Job No. 188423

July 19, 2022

Re: Response to CGS Comments
515 Struthers Loop
Pair-A-Dise Subdivision, Filing No. 1
El Paso County, Colorado

PAIR-A-DISE SUBDIVISION FILING NO. 1

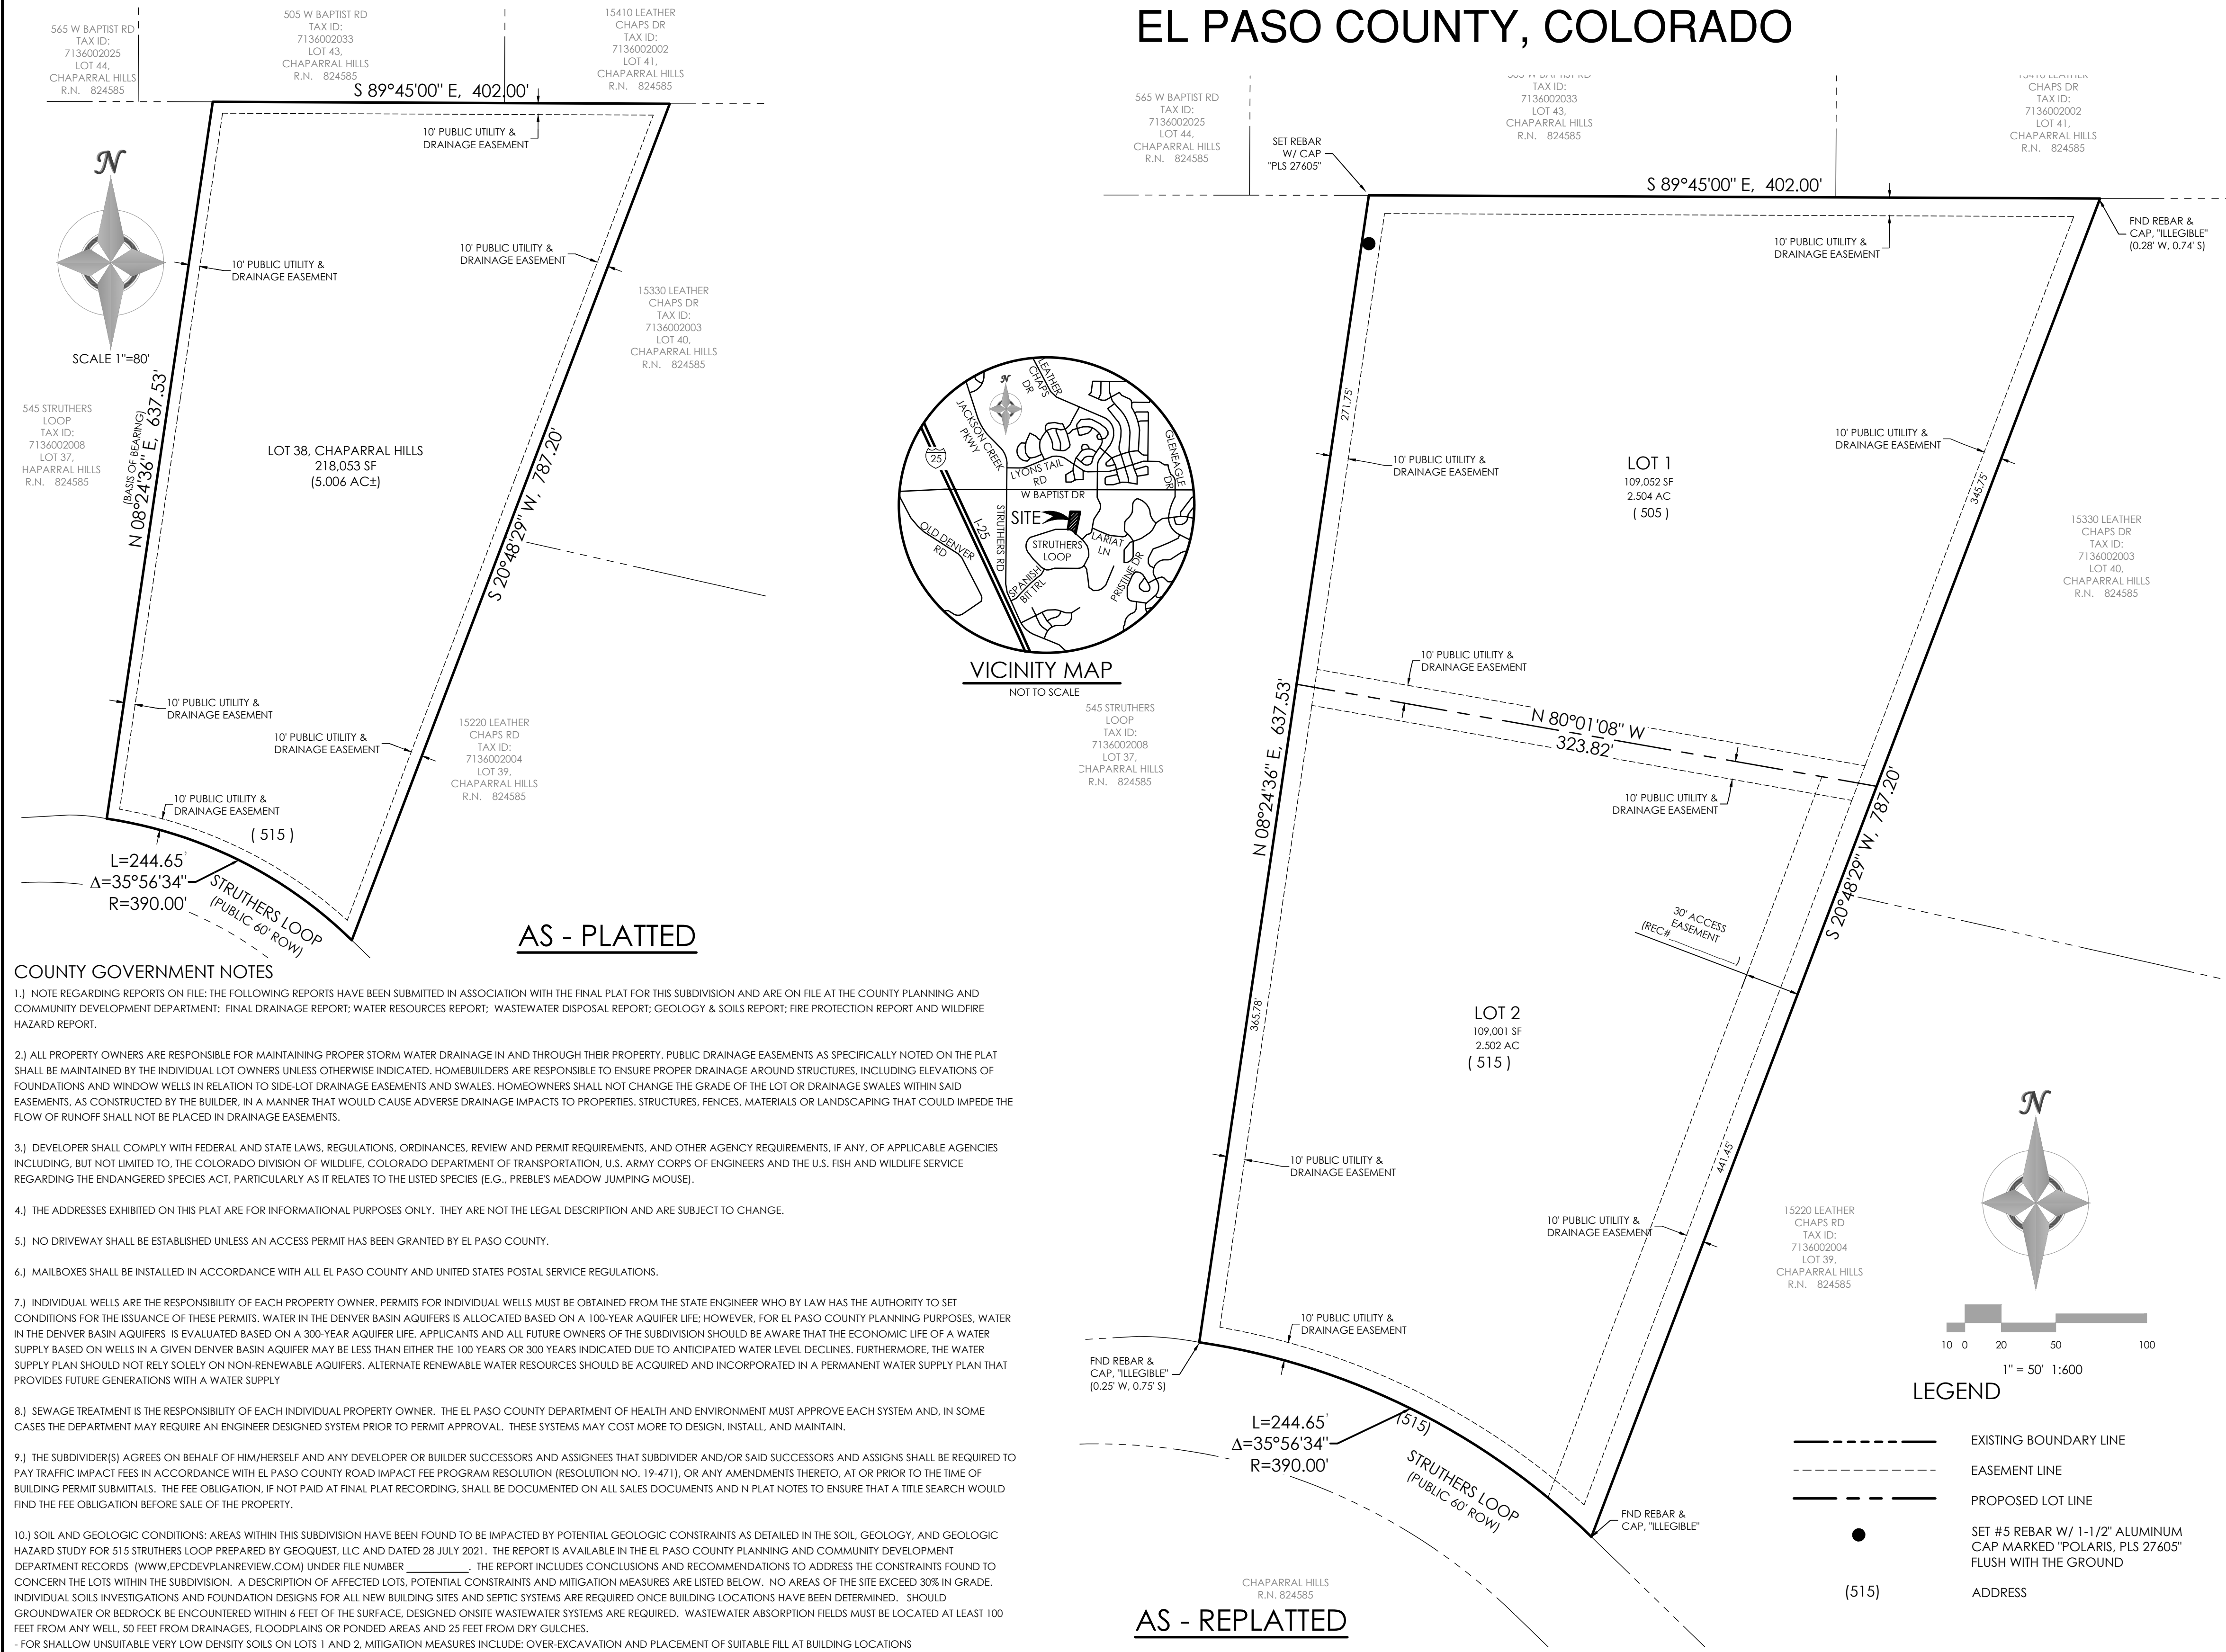
Plat note 10 references the Geoquest report (July 28, 2021). CGS recommends that Plat Note 10 be updated to reference the date of RMG's updated report.

RMG has requested Mr. Atwood have Plat note 10 updated to reference our amended report, dated July 19, 2022.
